From: Anita Gardner <Anita.Gardner@arun.gov.uk>
Sent: 20 February 2020 16:29
To: Planning.Responses <Planning.Responses@arun.gov.uk>
Subject: FW: R/268/19/PL 6 Manor Road, Rustington

To: Stephen Garrard
Subject: R/268/19/PL 6 Manor Road, Rustington

Fig 4. Extract from Proposed Site Plan

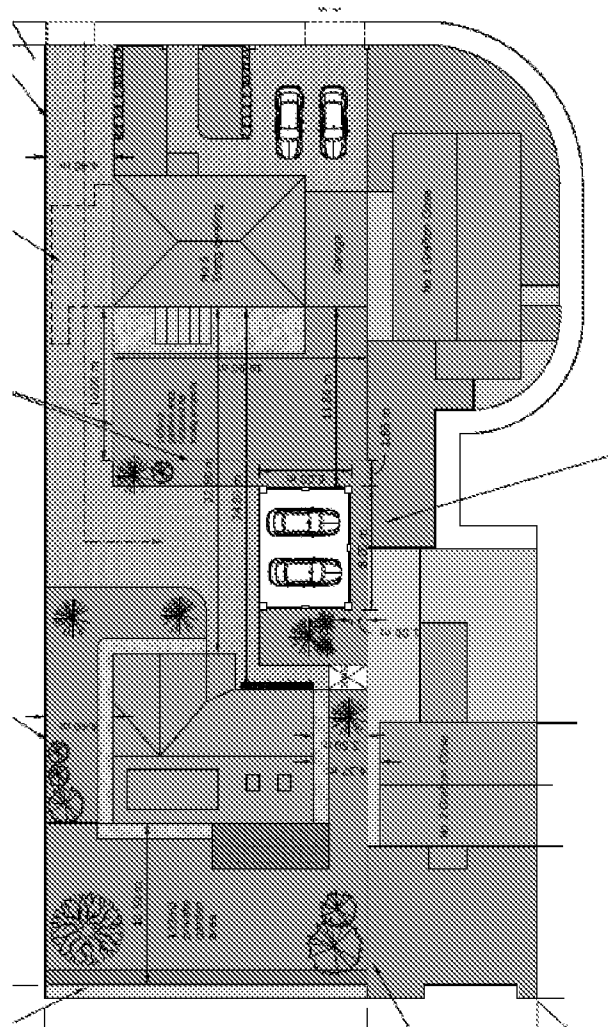
After reviewing the amended plans I have noticed that they now wish to narrow the proposed drive way, as a result and per our previous comments we need to internally consult the Fire & Access Team in regards mitigation methods as a fire truck can no longer access the property. As this has its own time requirements I can inform you that my response will not be to you within 48 hours.

Also this response will raise the 'to be submitted' requirements for the extension of the VCO at number 6 as with the extension of the parking area we would require the extension of the VCO as well.
